## Engineers Comments Regarding Surface Water Drainage

<b>Application Reference:</b>	BE/48/25/PL	<b>Reviewer Reference:</b>	ADC/EXT4
<b>Planning Officer:</b>	Amber Willard	<b>Date of Review:</b>	21/07/2025
<b>Site Name:</b>	Rear of Regal House And Wayside Shripney Road Bognor Regis PO22 9NP		
<b>Application Description:</b>	7 No. residential dwellings and associated works including new access. This application is a Departure from the Development Plan and is in CIL Zone 3 and is CIL Liable as new dwellings.		
<b>Assessment Number:</b>	1 of 1

Tank Structure at Manhole S2

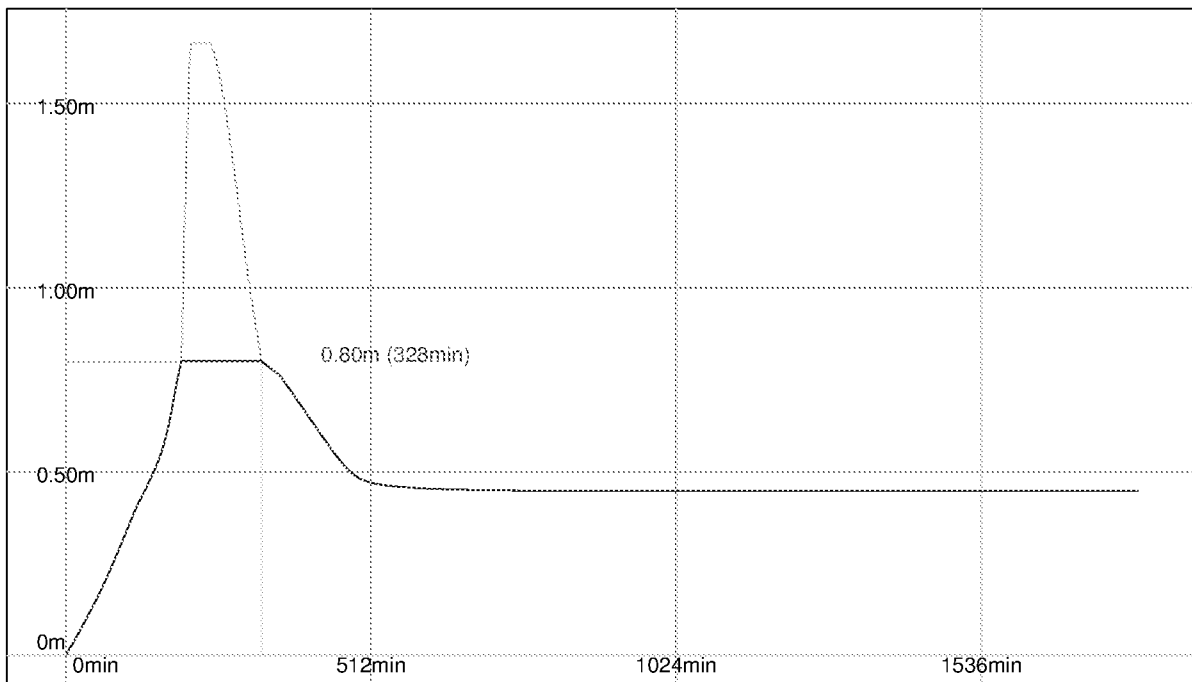
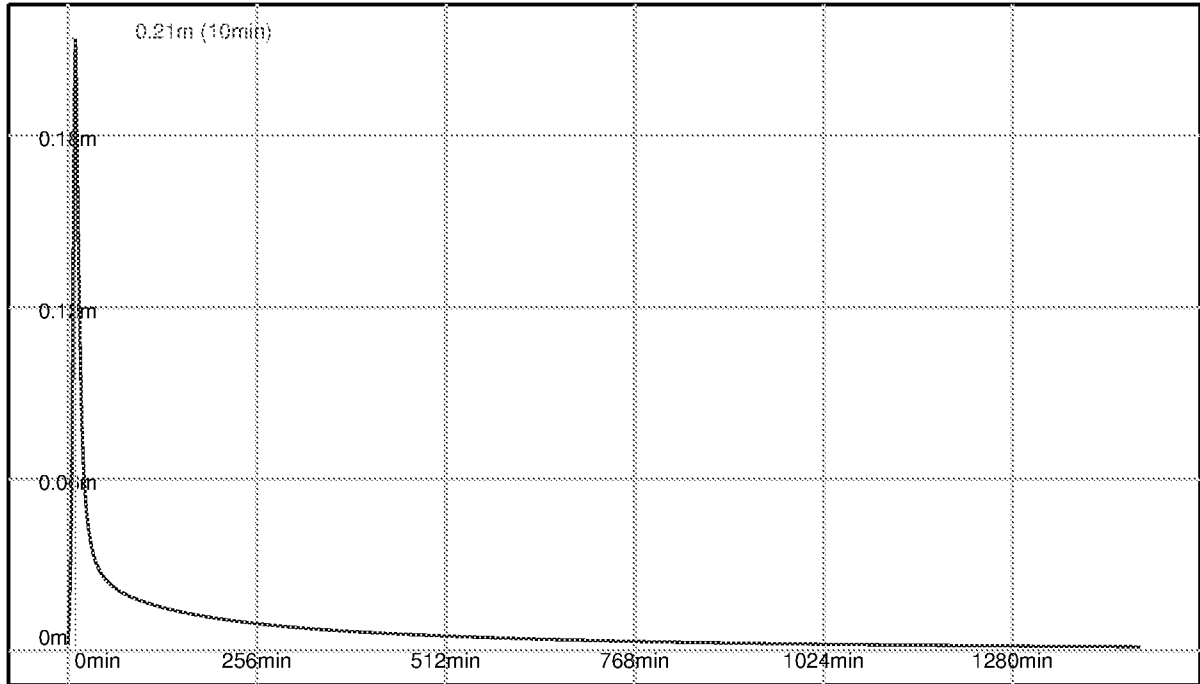
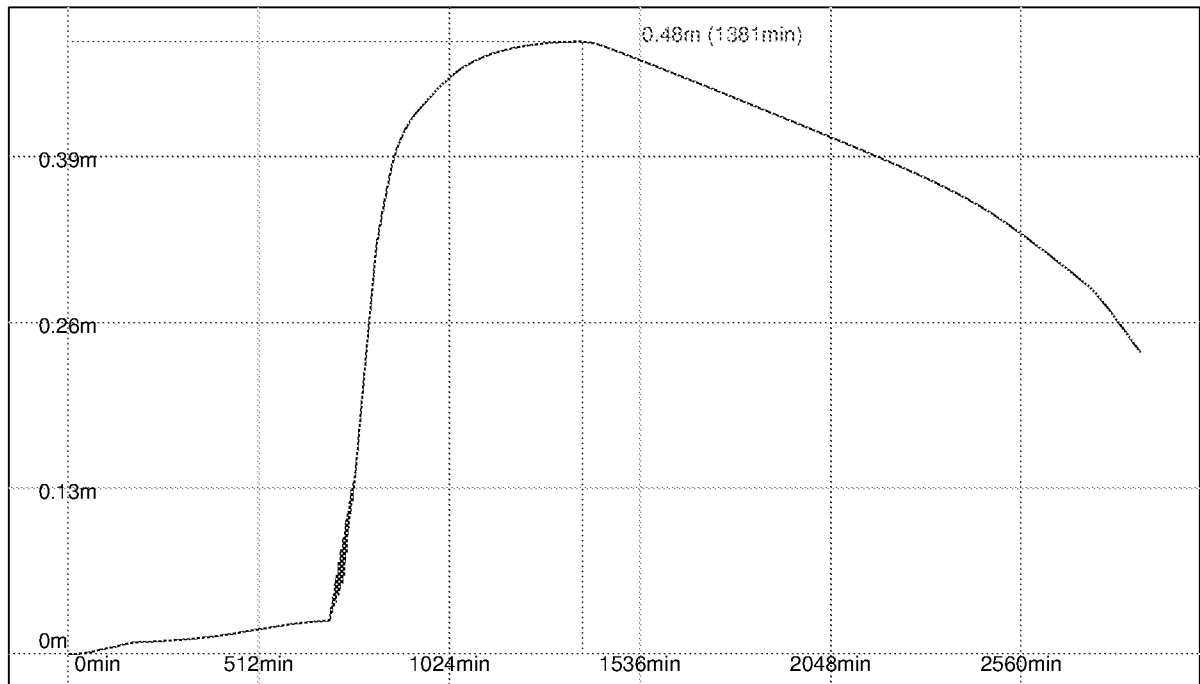
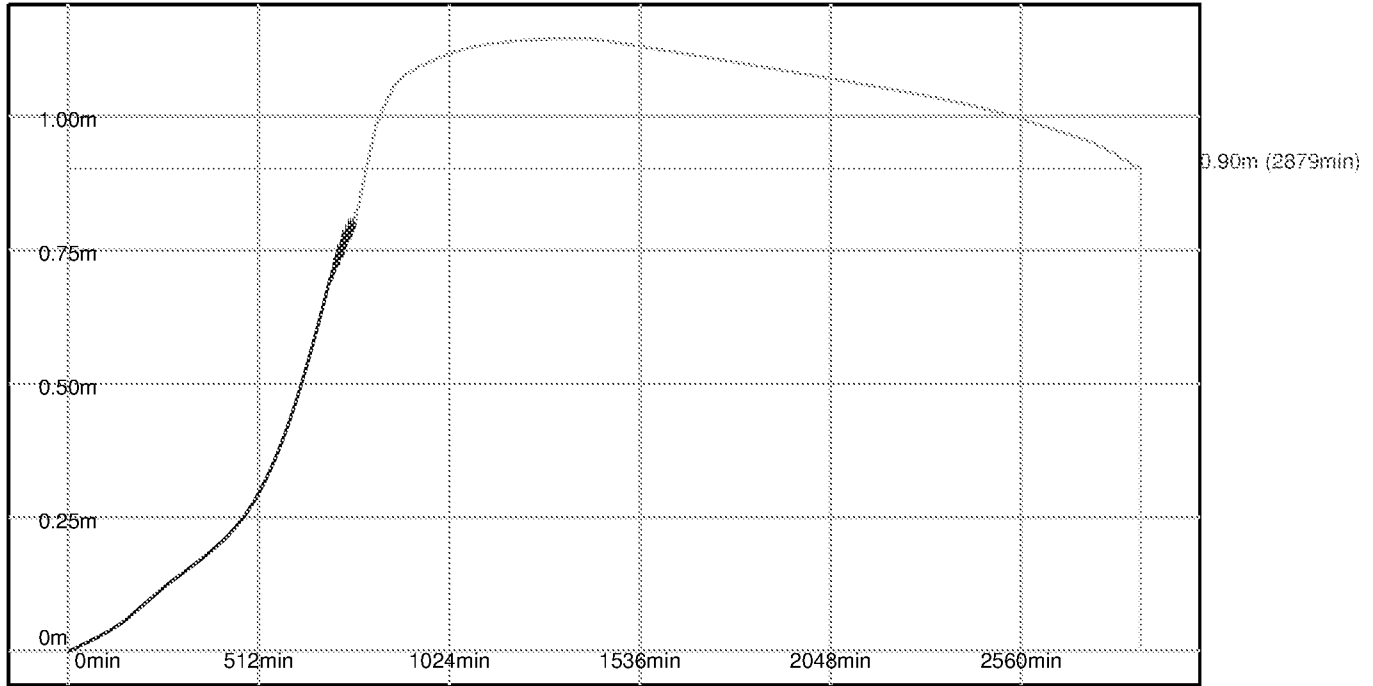
<p>The condition, performance (including capacity where appropriate) and ownership of any existing site surface water drainage infrastructure must be accurately reported.</p> <p>Appropriate easements to watercourses and other services must be shown on all plans.</p> <p>Where there are areas of flood risk from any source on the site, it must be shown how a sustainable surface water drainage design can be accommodated on the site without conflicting with those areas of flood risk.</p> <p>Designs must replicate the natural drainage catchments of the site. All surface water drainage designs must therefore drain via gravity to corresponding points of discharge.</p> <p><b>The use of pumps for surface water drainage is not sustainable and will only be considered where the designer has fully demonstrated that they are proposed as a last resort.</b></p>	<p><b>Not supplied</b> Condition of highway sewer not indicated for catchment A. Condition of surface water sewer being connected to and headwall outfall are not indicated for catchment B and whether both connections are feasible based on current condition.</p> <p><b>Not supplied</b> easements not indicated on plans</p> <p><b>Not supplied</b> There is flooding noted at Manhole S3 with no details of how this is to be retained within the site.</p>

<p><b>Plans</b></p>	<p>Plan areas, depths and levels of drainage infrastructure must accurately correspond with the supporting calculations.</p>	<p><b>Insufficient</b> Drainage plan indicates Geocellular soakaways for both catchments but calculations suggest these are attenuation tanks-please clarify. Tank depths/Invert Levels do not match calculations-please clarify.</p>
<p><b>Water quality benefits.</b></p>	<p>An assessment of water quality is necessary to evidence that the proposed design provides adequate treatment of surface water.</p>	<p><b>Not supplied</b> No details are provided of water treatment to catchment A. The applicant will need to consider to provide a form of surface water treatment for run-off from this catchment</p>
<p><b>Biodiversity and amenity benefits.</b></p>	<p>The surface water drainage design must provide biodiversity and amenity benefits.</p>	<p><b>Not supplied</b></p>

1. Baseline hydrology plan outlining existing drainage regime
2. Details of how flooding volume is retained within site
3. Details of water treatment being provided to the western catchment prior to connection of the highway drain.
4. Proposed trees being indicated on drainage plan to confirm there are no clashes.
